Our ref: L.A11230.003.StPhilipsCC-RTS.docx

25 October 2022

RE: RESPONSE TO SUBMISSION - ST PHILIP'S CHRISTIAN COLLEGE, CESSNOCK SSDA

Table 1.1 Response to Submission

BMT endeavours to ensure that the information provided in this map is correct at the time of publication. BMT does not warrant, guarantee or make representations regarding the currency and accuracy of information contained in this map.

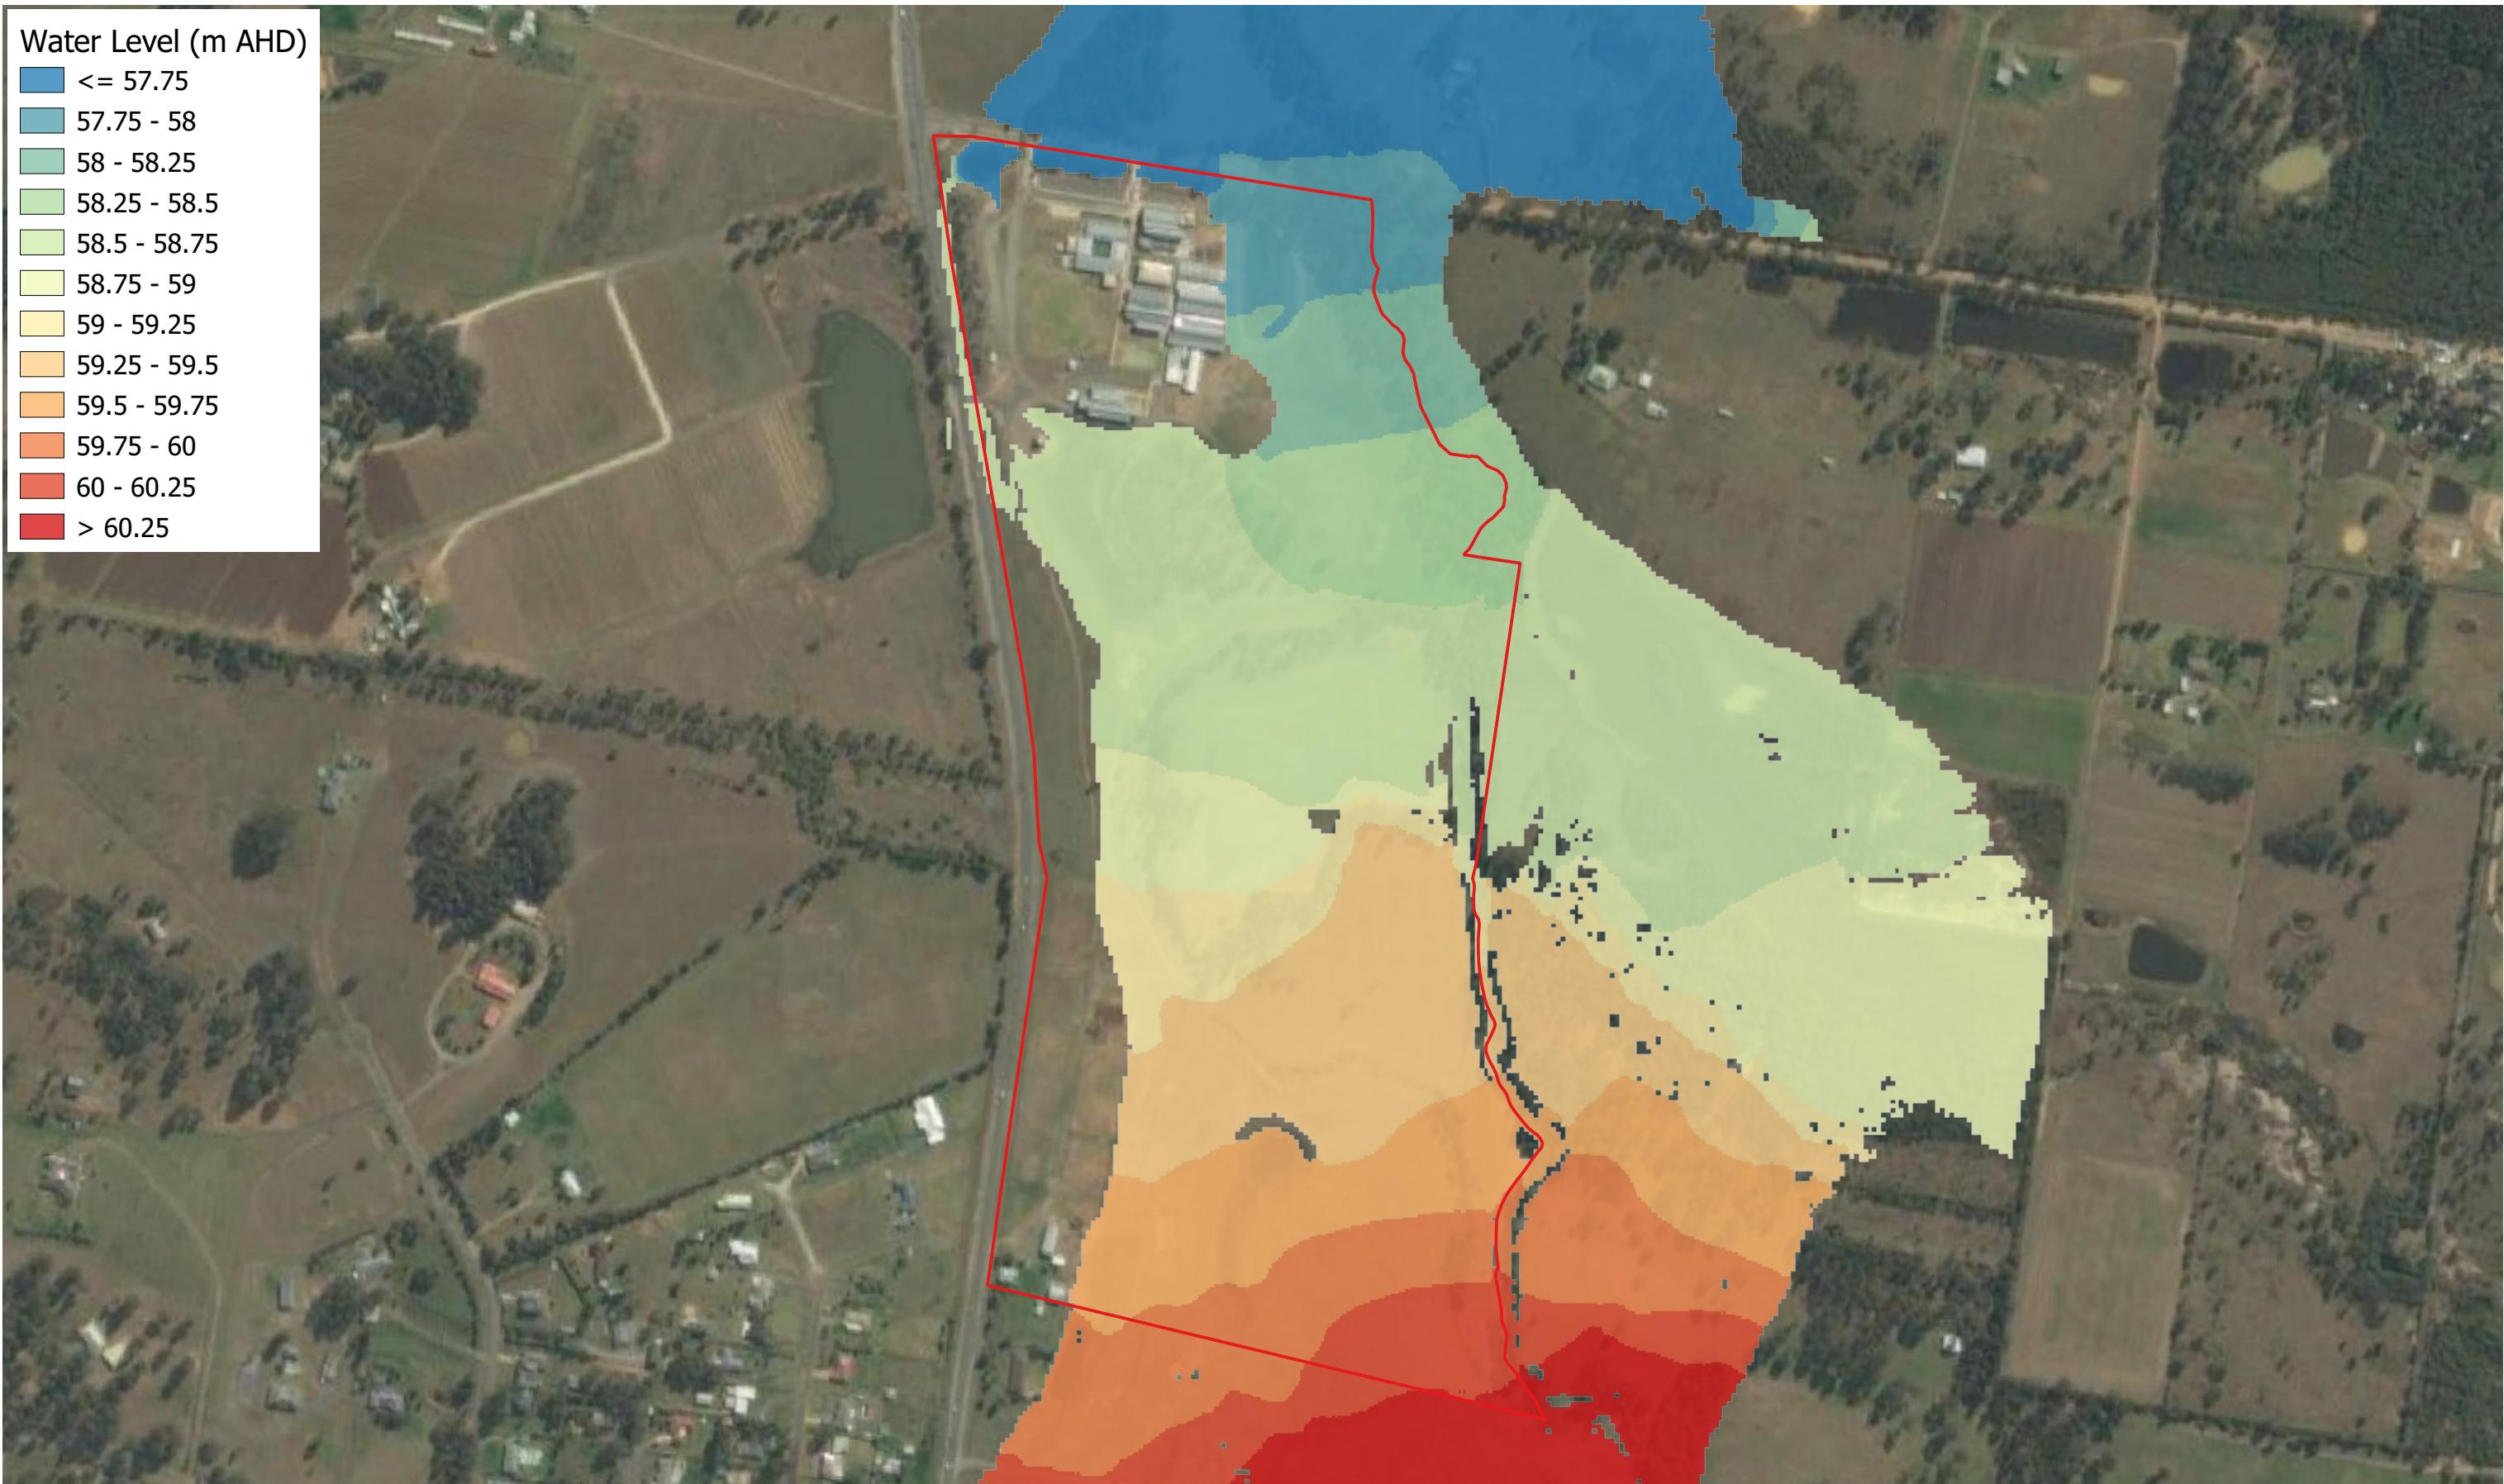
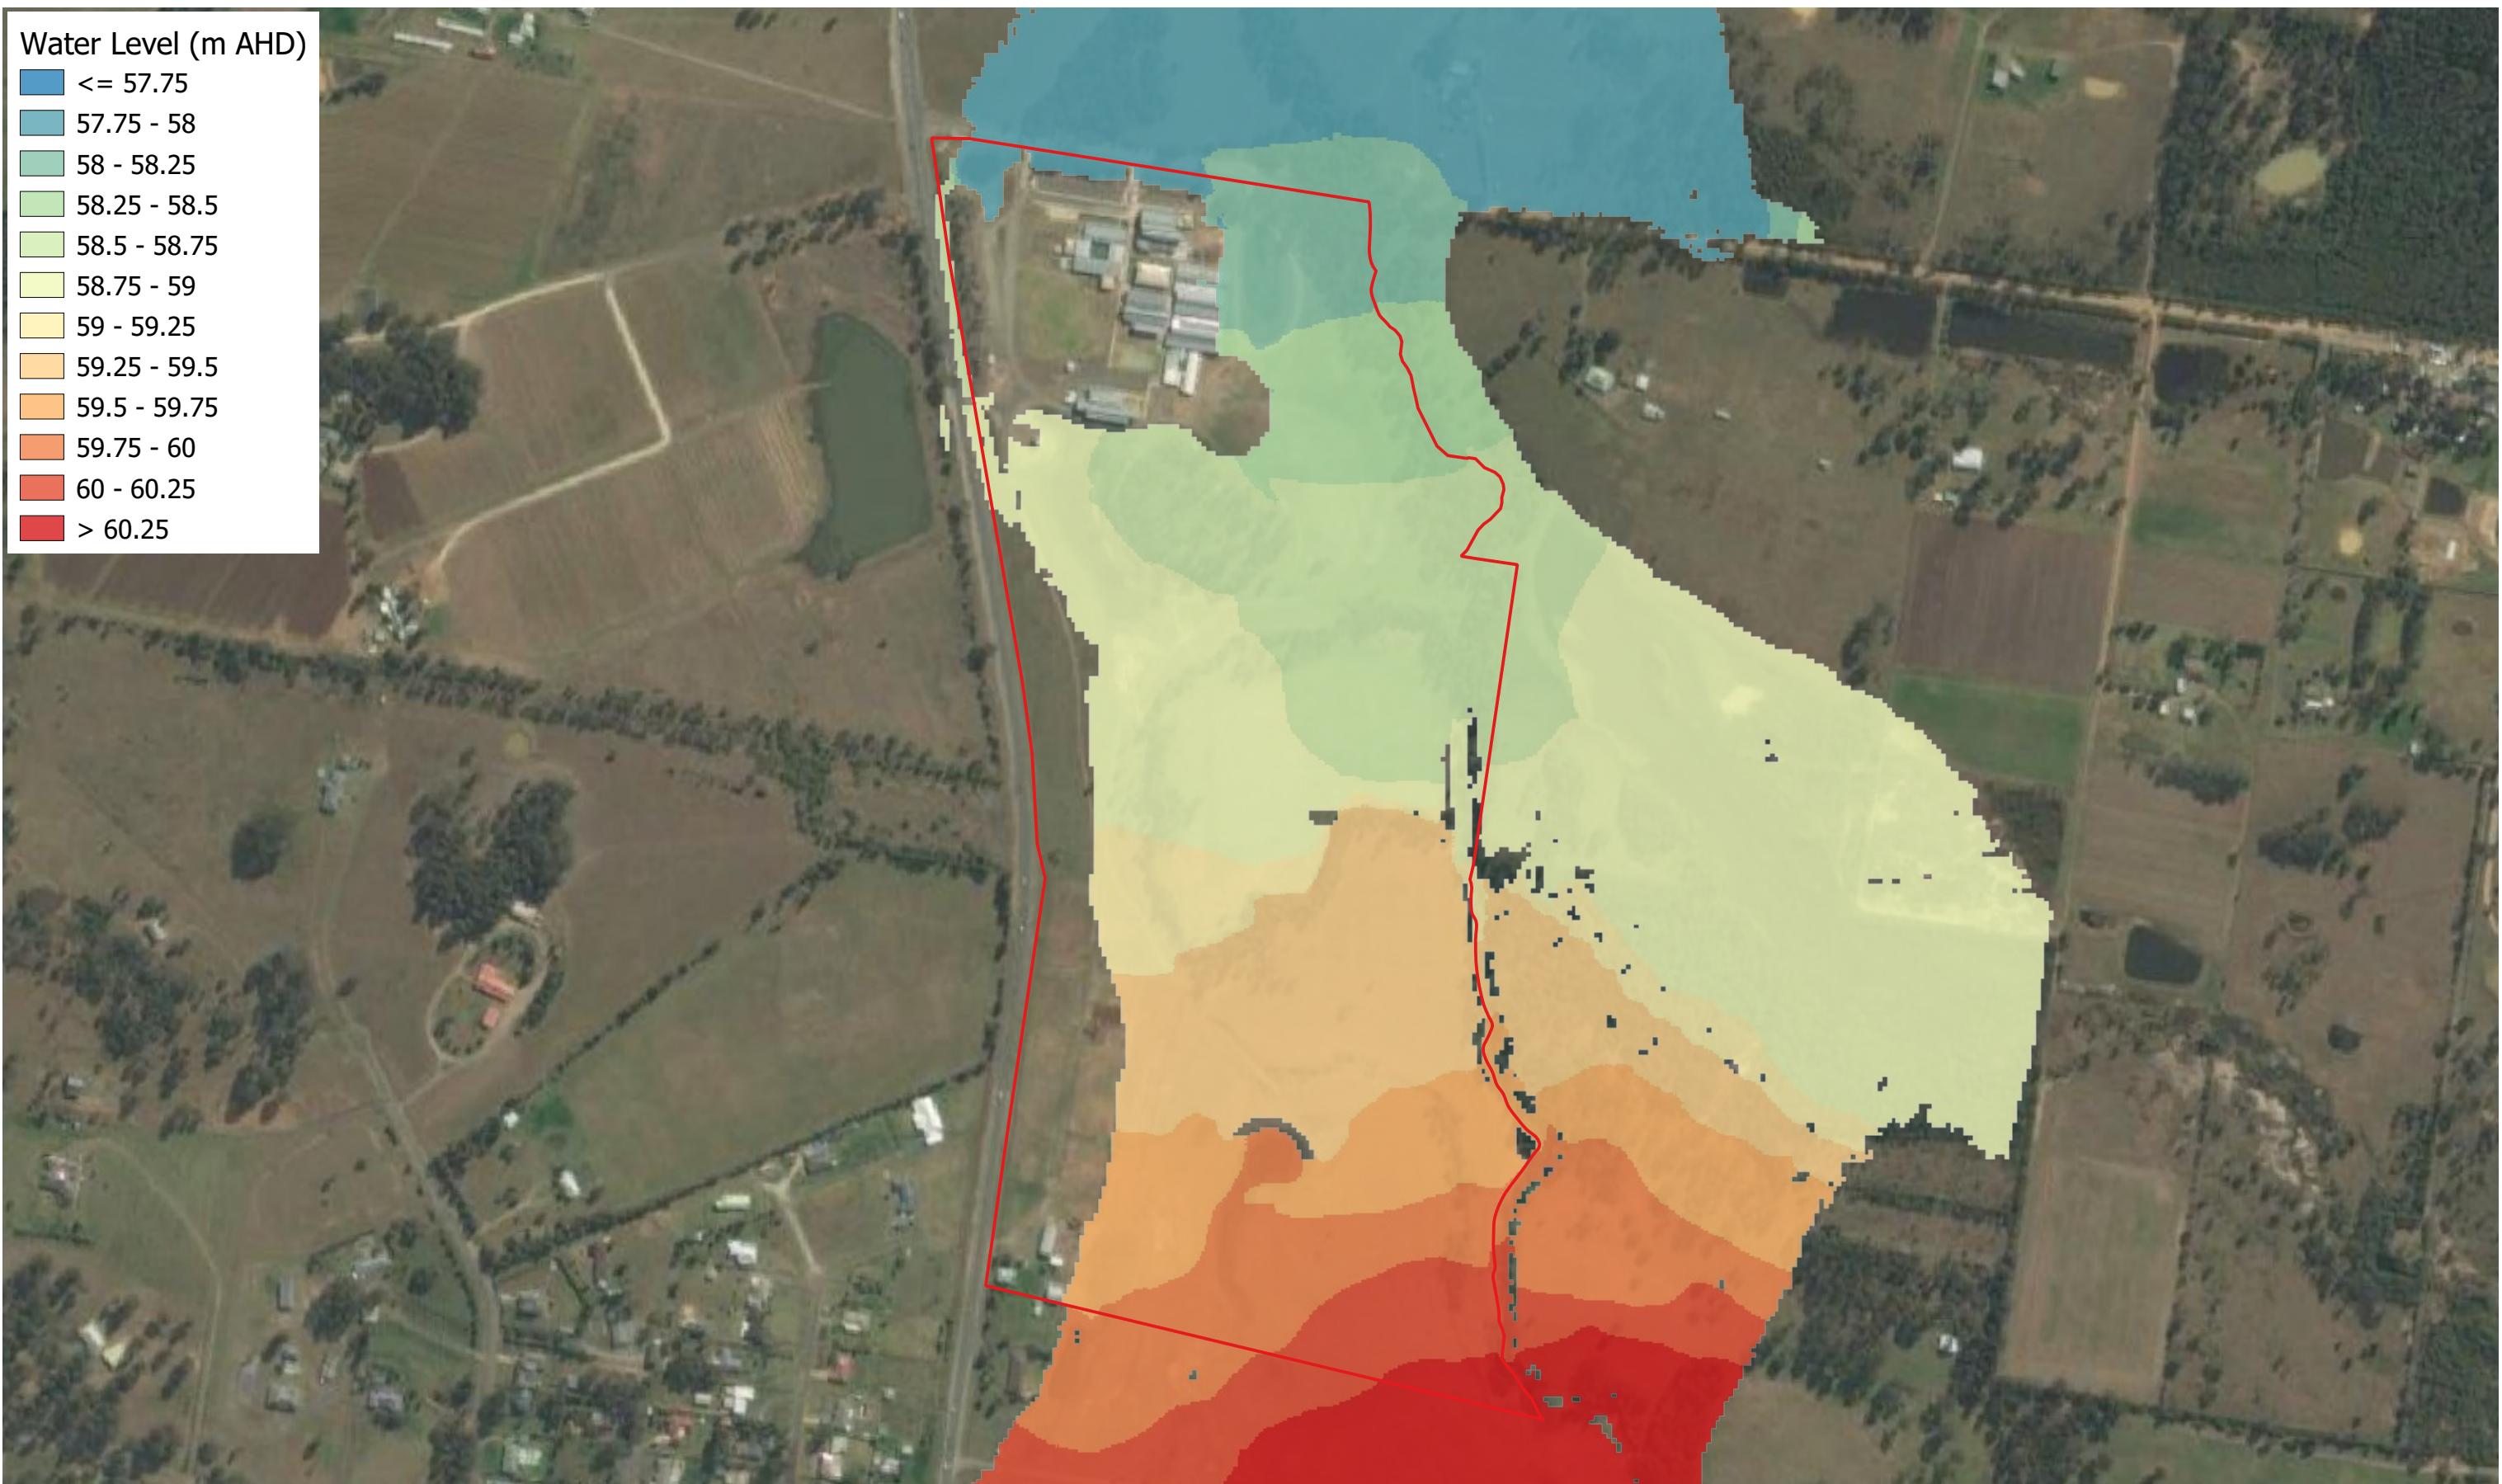
• <i>Distribution of flood water is shown to increase between 20-50mm along the eastern boundary to Lot 892 DP 574957.</i>	Whilst offsite flood impact due to the proposed development is predicted to occur for the 2% AEP event and above, the peak flood level increase beyond the acceptable 20mm threshold is marginal (which occurs in area subject to typical peak flood depth in excess of 1m) and the impacted extent is confined within the Black Creek corridor (negligible change in encroachment). Neither the existing residential building within the neighbouring lot (Lot 892 DP 574957) is affected nor the flood hazard of the impacted area is significantly altered (hence minimal change to existing flood risk).
<u>Department of Planning and Environment</u>
